**Consultation Response from KC,
Lead Local Flood Authority**

2024/91007 adj, 208, Yew Tree Road, Birchcliffe, Huddersfield, HD2 2EQ

Discharge of conditions 6 (Phase II report), 7 (Remediation Strategy), 10 (affordable housing), 11 (public open space), 12 (education), 13 (sustainable transport), 14 (temporary drainage), 16 (drainage scheme), 17 (attenuation and discharge rate), 18 (access point), 19 (estate roads), 21 (footway details), 23 (construction management plan), 24 (noise report), 25 (ecological design strategy) and 26 (electric vehicle charging) of previous permission 2018/90151 for outline application for erection of residential development

Conditions 16 & 17 – Drainage Details and Attenuation

TITLE
**FLOOD EXCEEDANCE
PLAN**

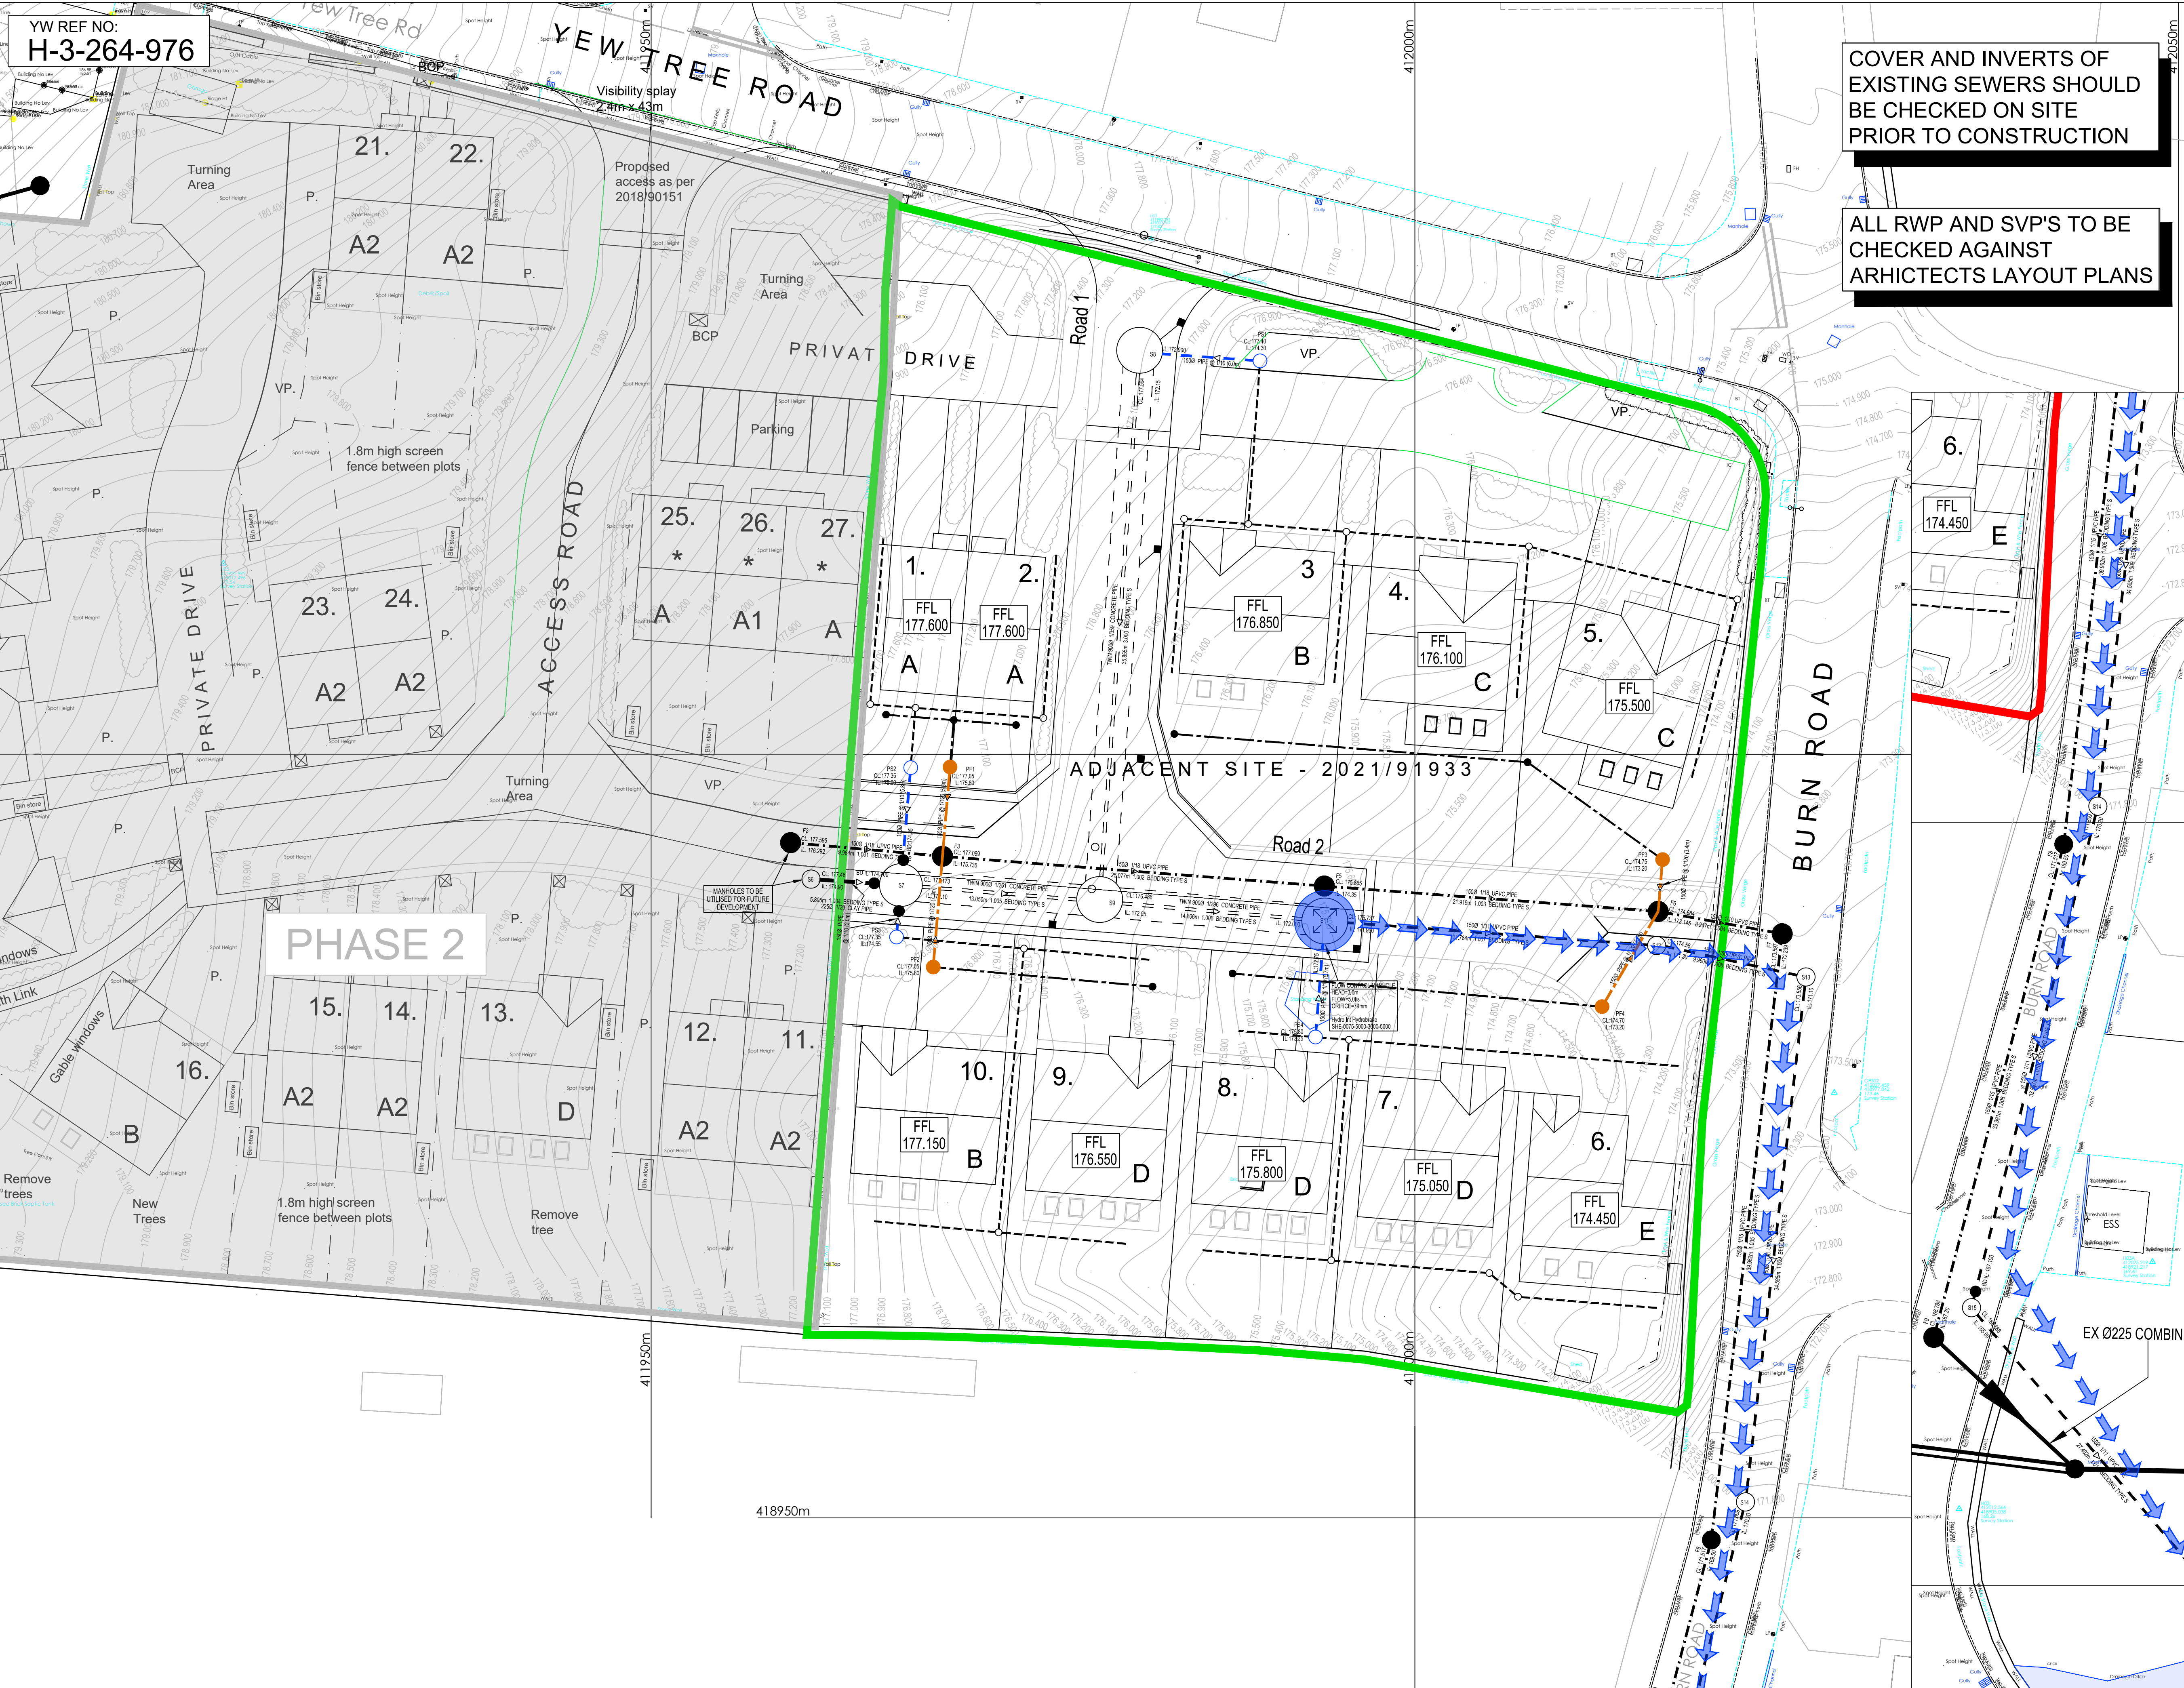
Cover levels on private sewer drainage layout now correspond to flood routing drawings.

YW REF NO:
H-3-264-976

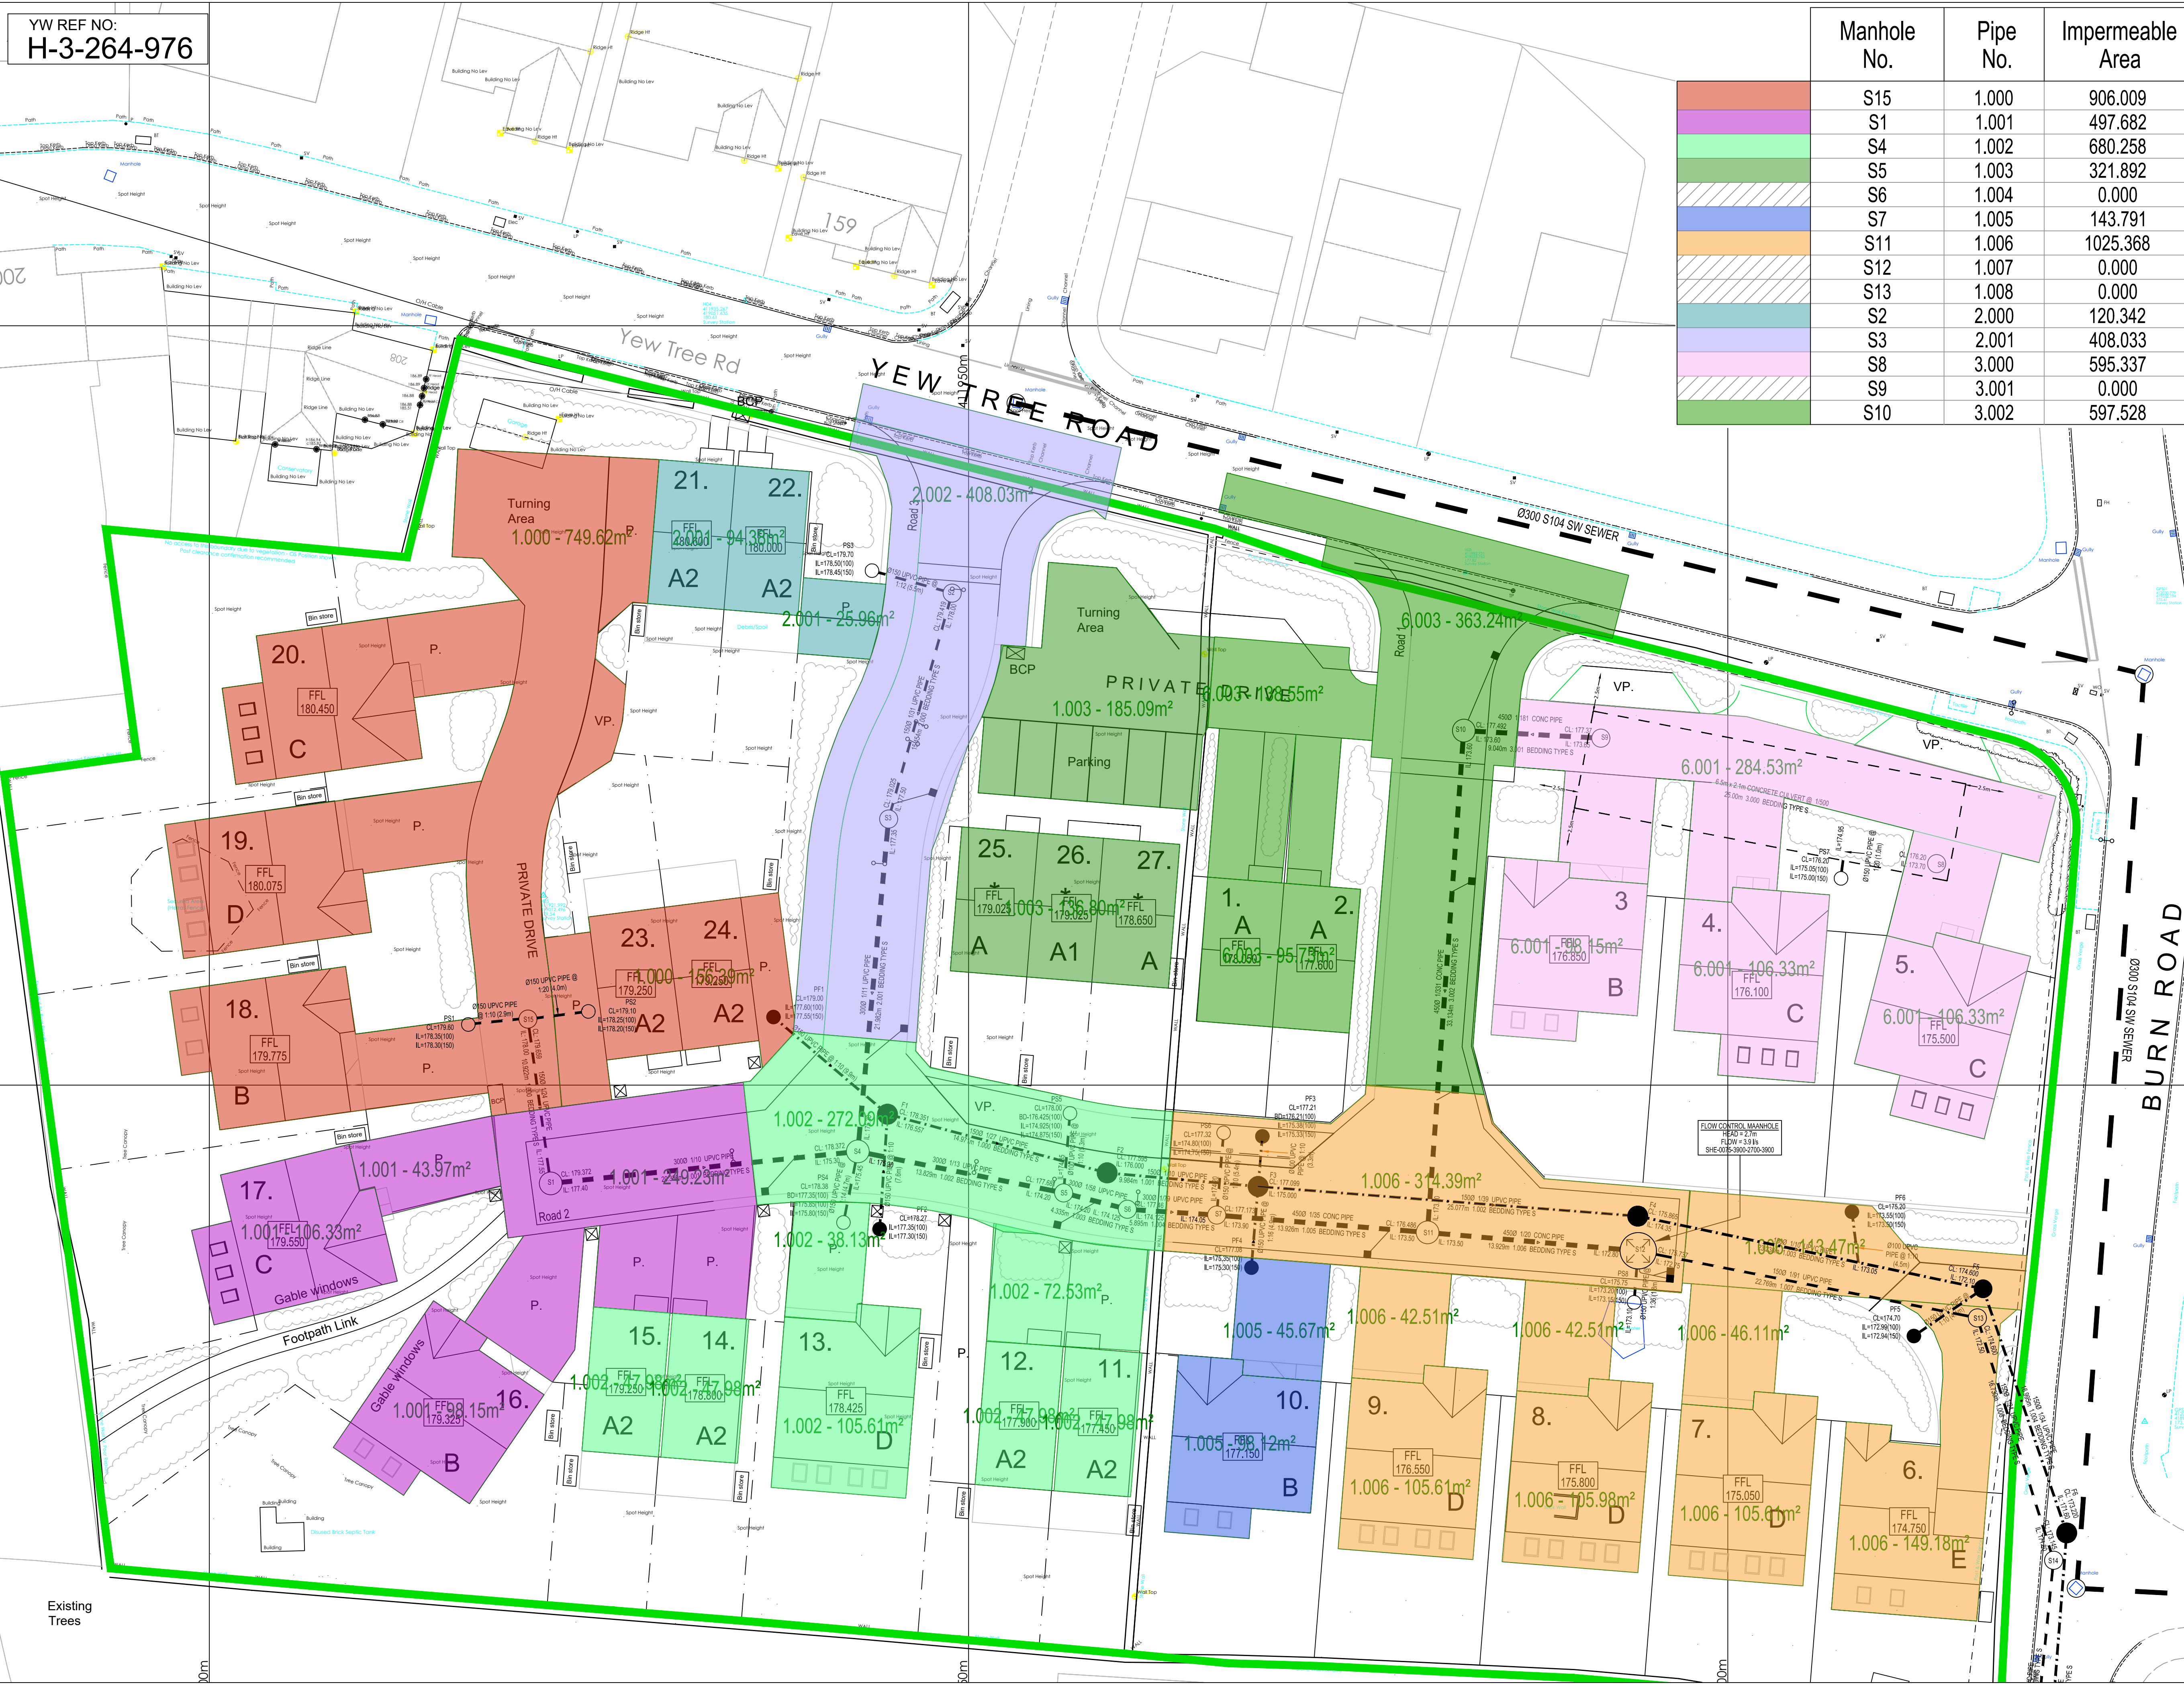
However, the latest impermeable area drawings still show anomalies, i.e. plots 11&12 connected to the wrong sewer leg in comparison to drainage drawings. The applicant should show that all comply with hydraulic simulations.
